Project #: 1007488 Application #: 12DRB-7072
Project Name: Sisters of the Order of St. Dominic
Agent: DKKER Pouch Sabatini Phone #:

September 24, 2008

DRB Comments

RE: Tracts D-1E-1, Sisters of the Order of St. Dominic

PLAT OF  
 TRACT D-1E-1A & D-1E-1B  
 SISTERS OF THE ORDER  
 OF ST. DOMINIC  
 CITY OF ALBUQUERQUE,  
 BERNALILLO COUNTY,  
 NEW MEXICO  
 MAY 2008

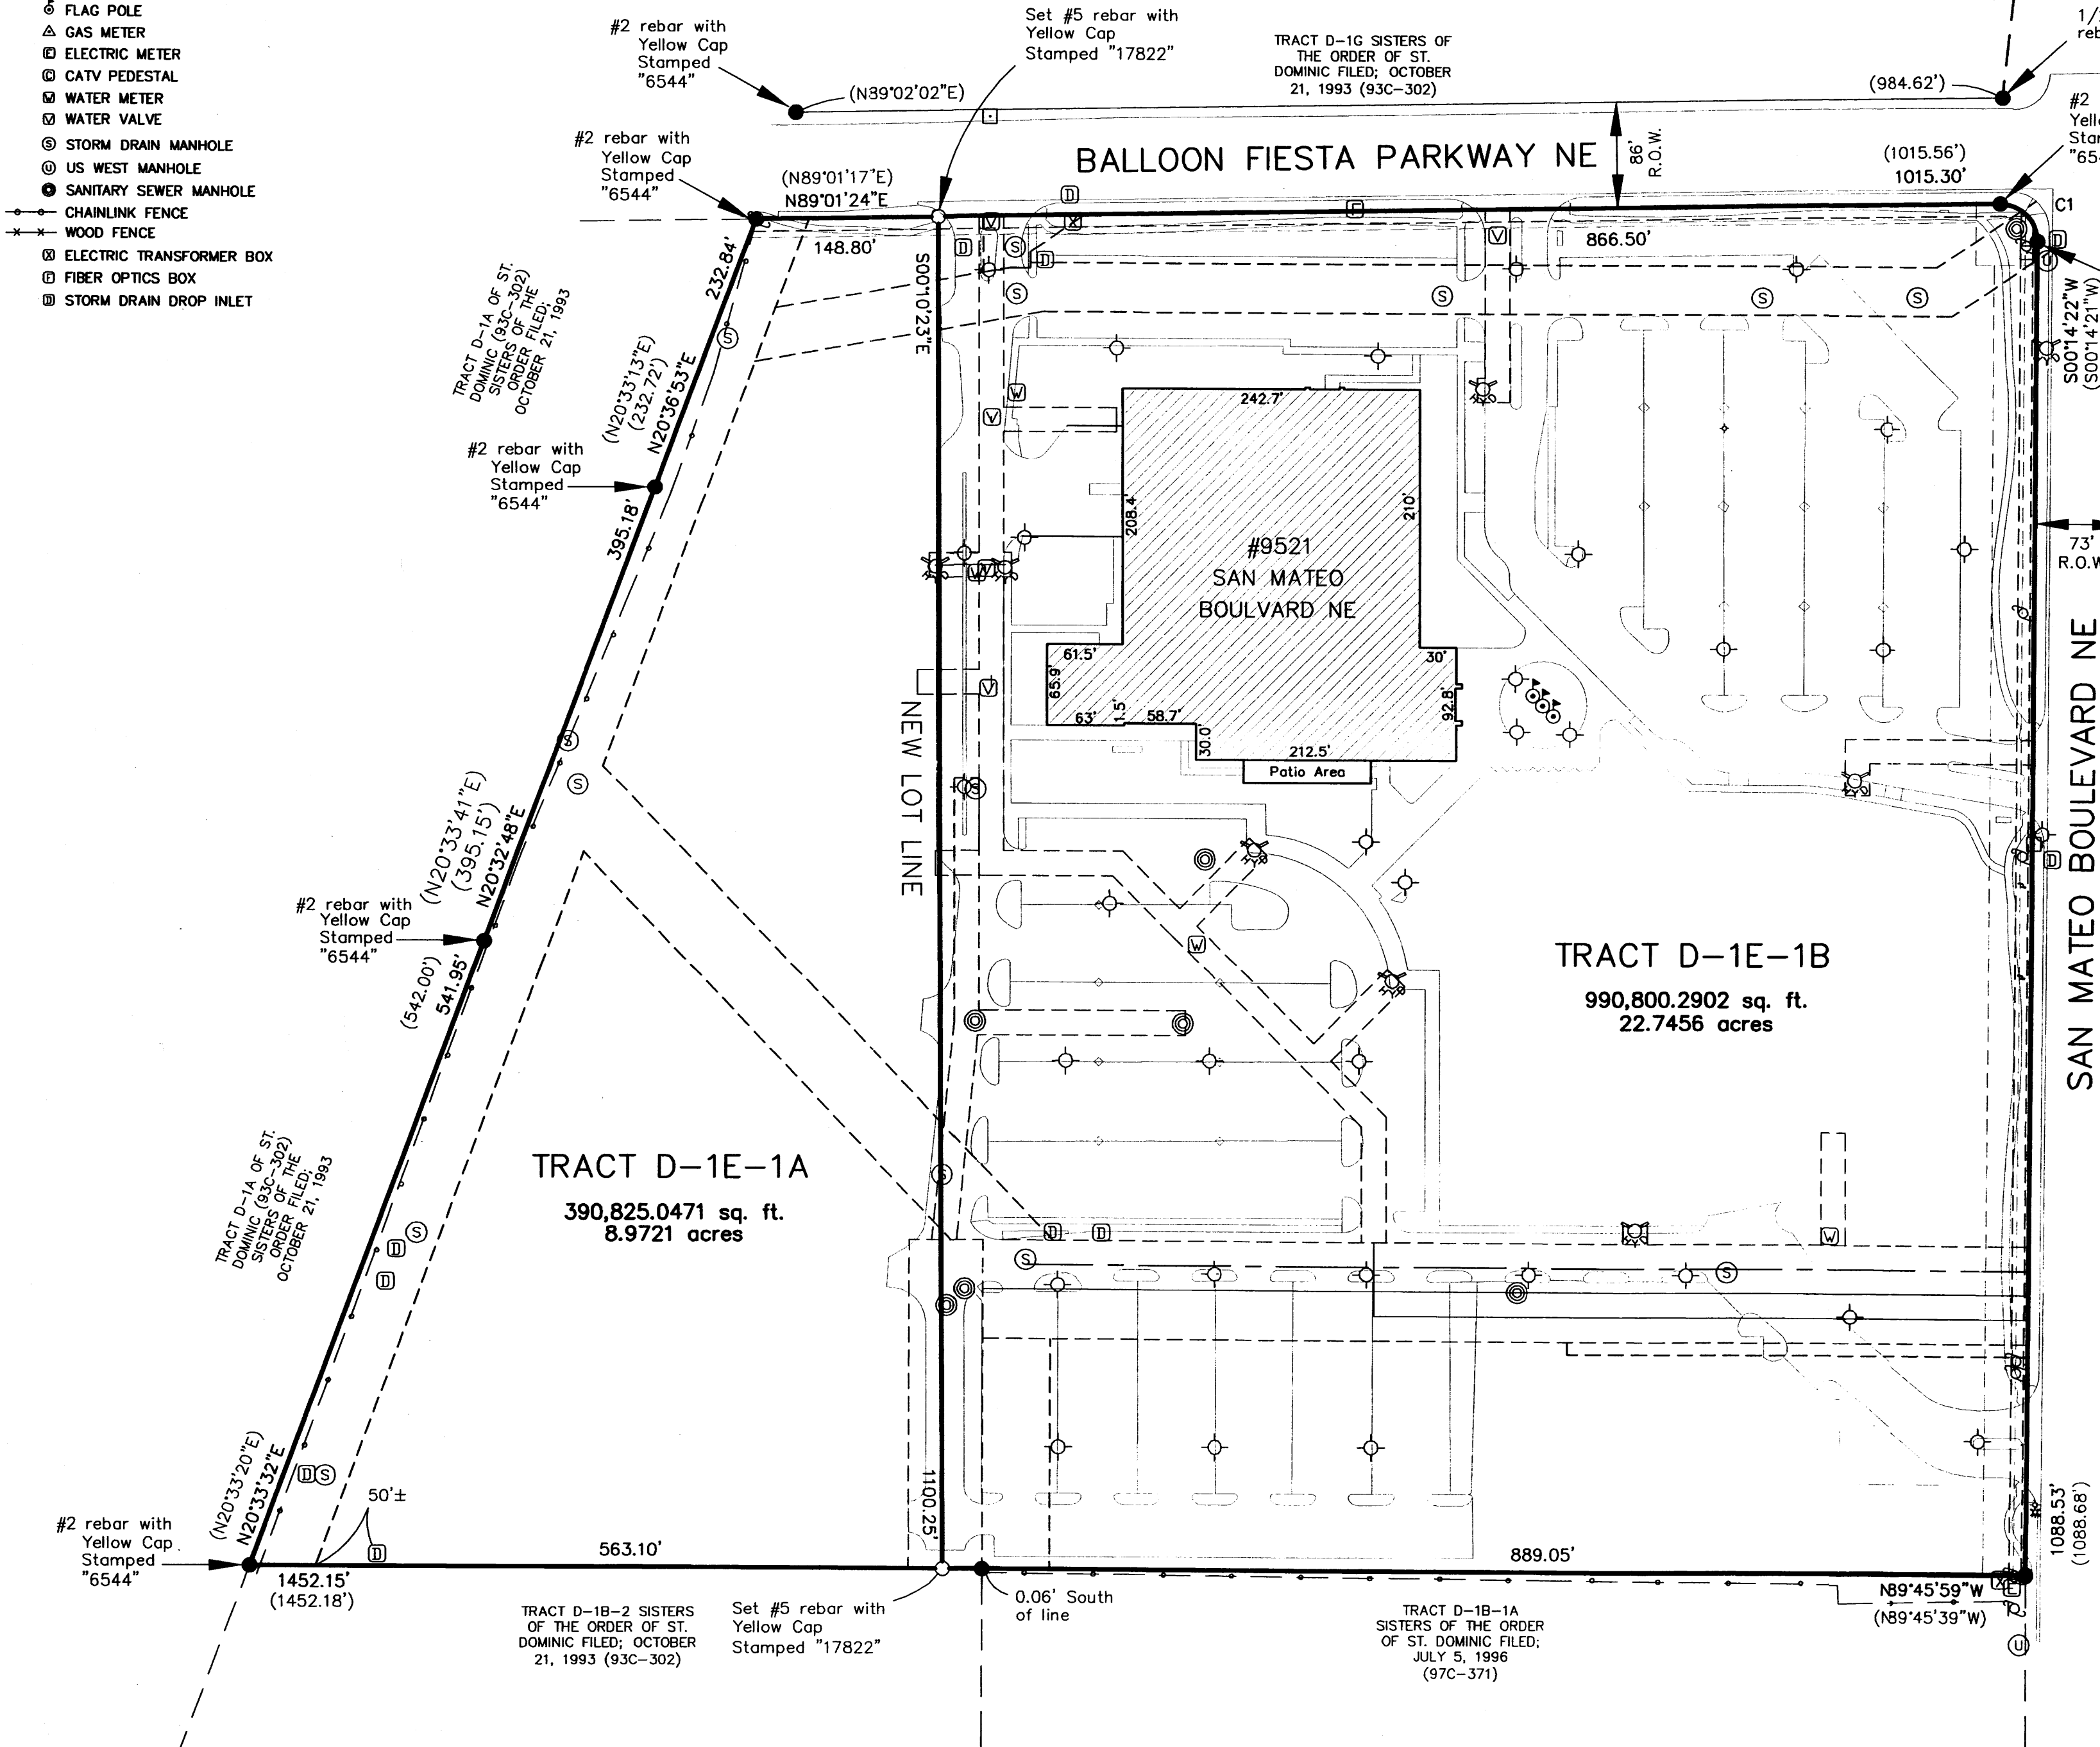
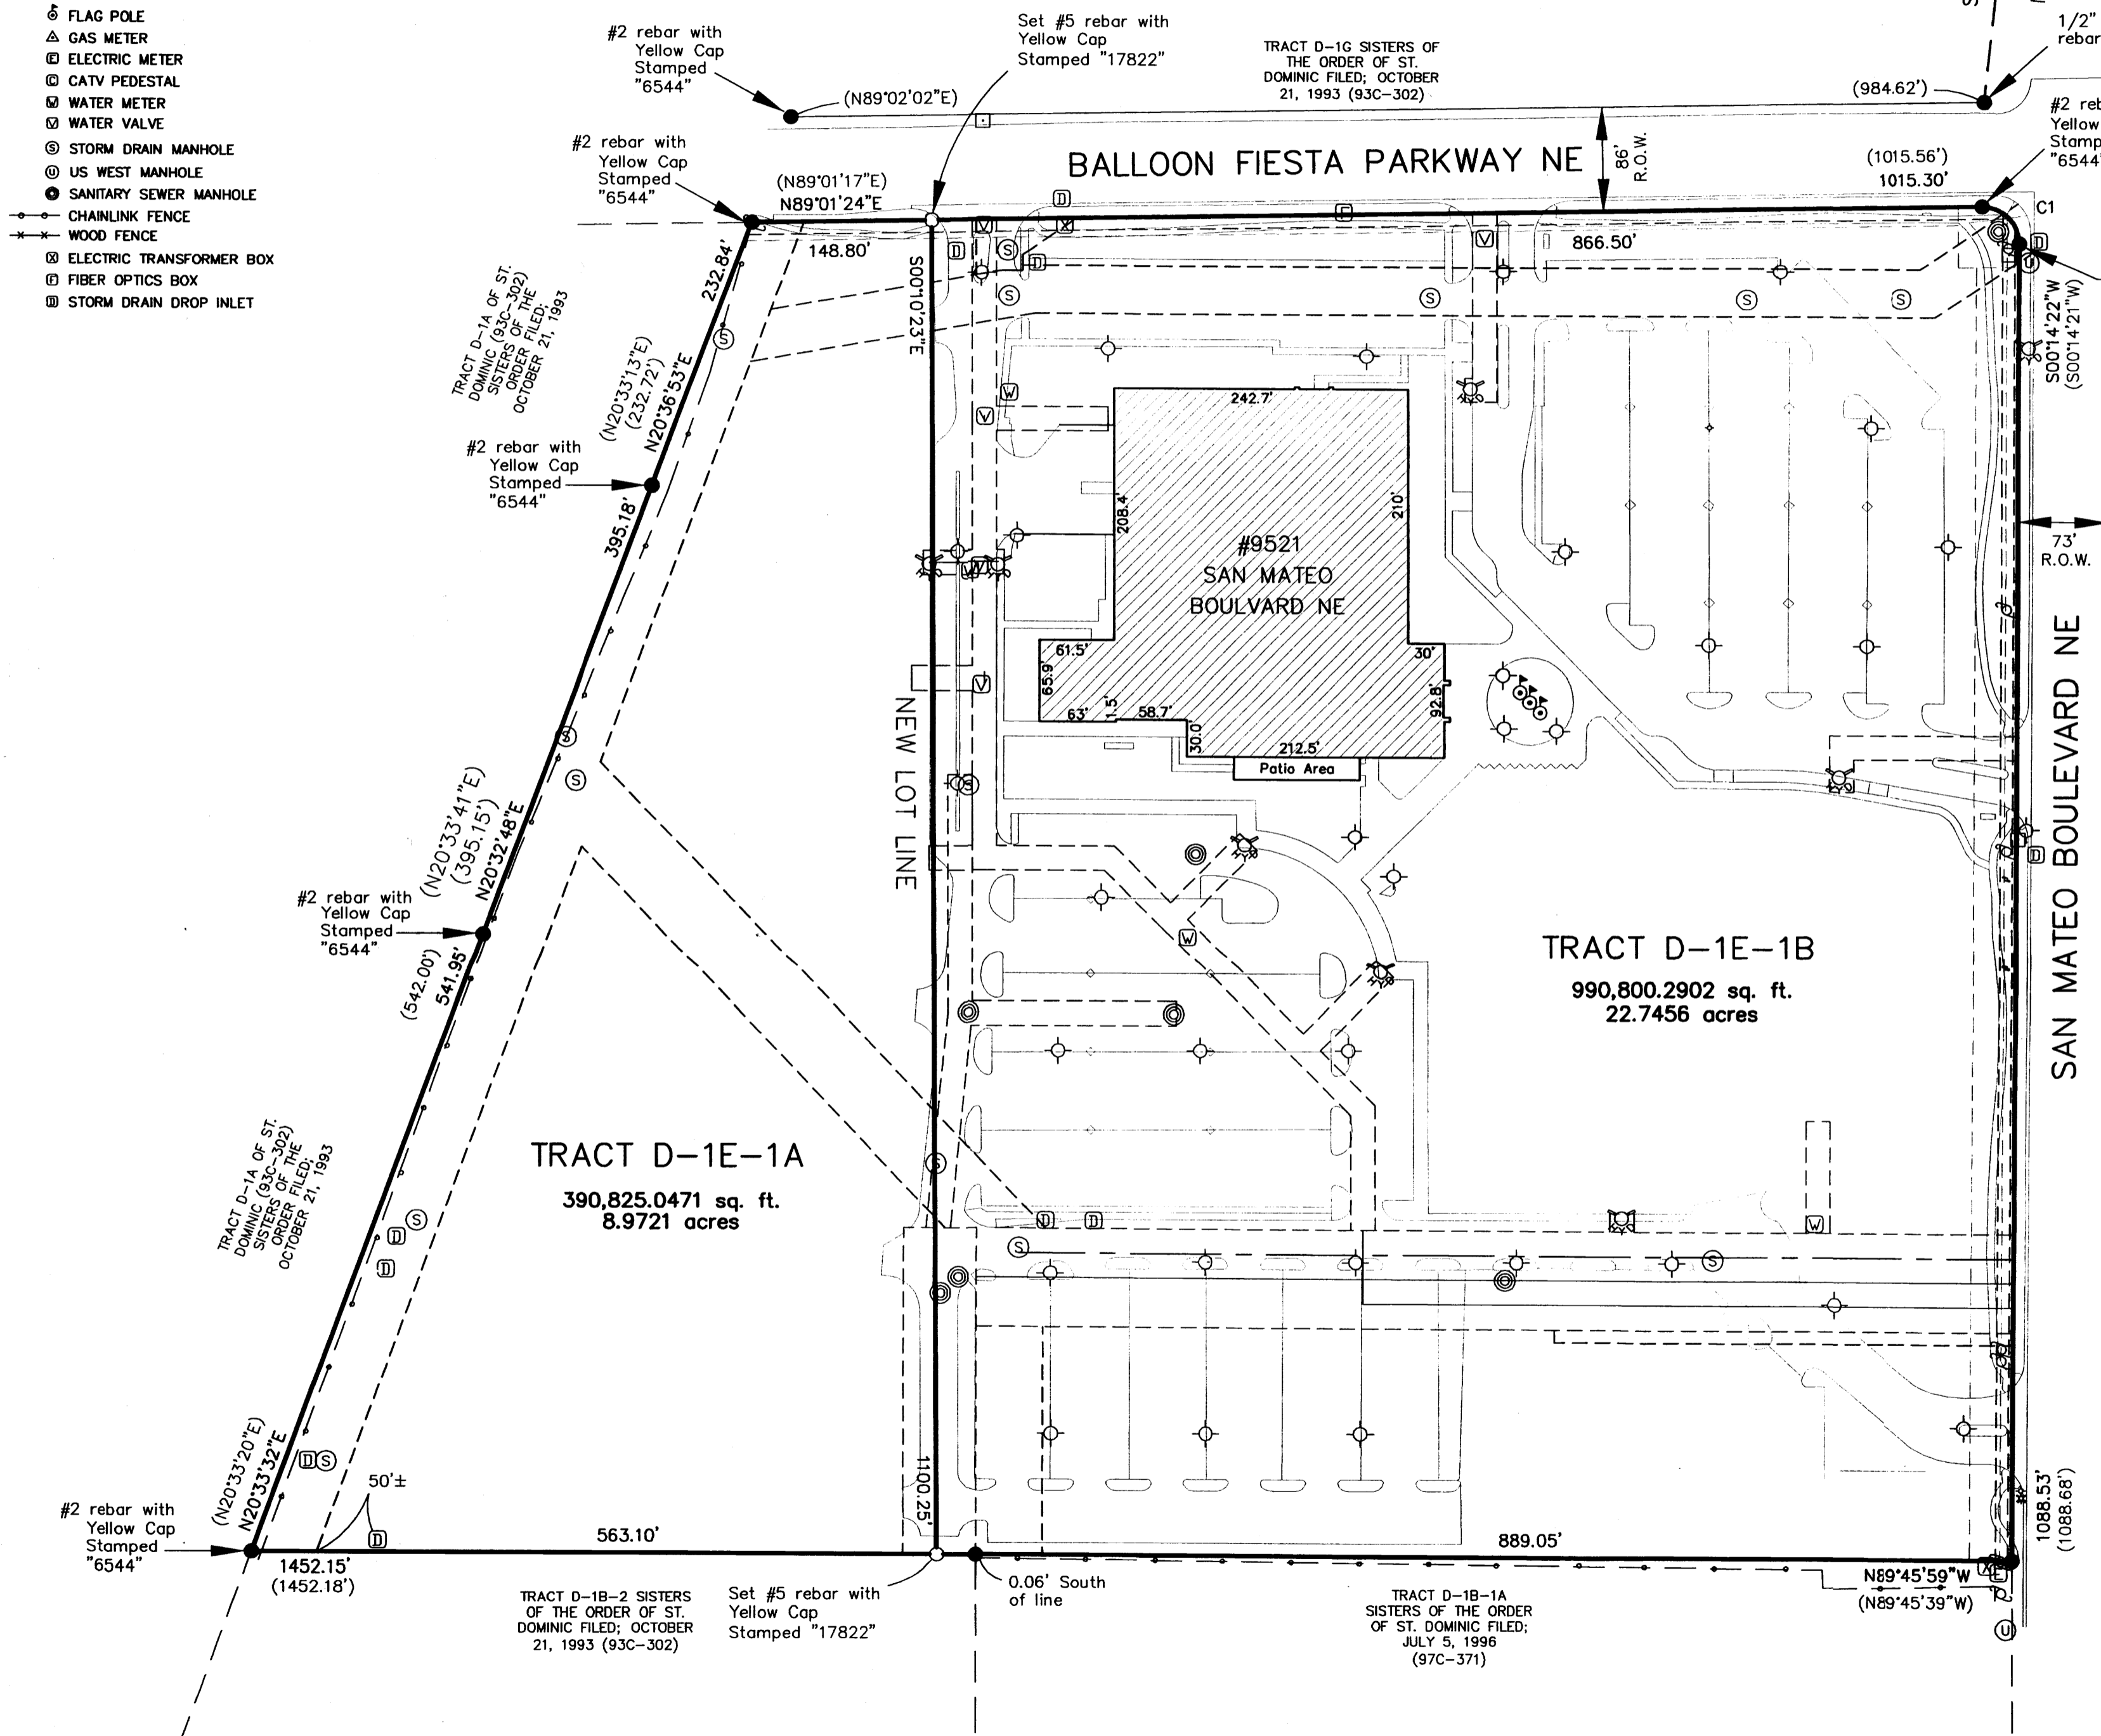
Please provide a Solar Note consistent with Section 14-14-4-7 which is specific to this type of request, i.e. use the words "THIS PLAT" (rather than the words "REQUESTED FINAL ACTION") at the beginning of the note, and don not use the words "OR SITE DEVELOPMENT PLAN FOR SUBDIVISION" at the end of the note.

An access easement is needed where the driveway of the south parking area overlaps onto proposed tract 1A.
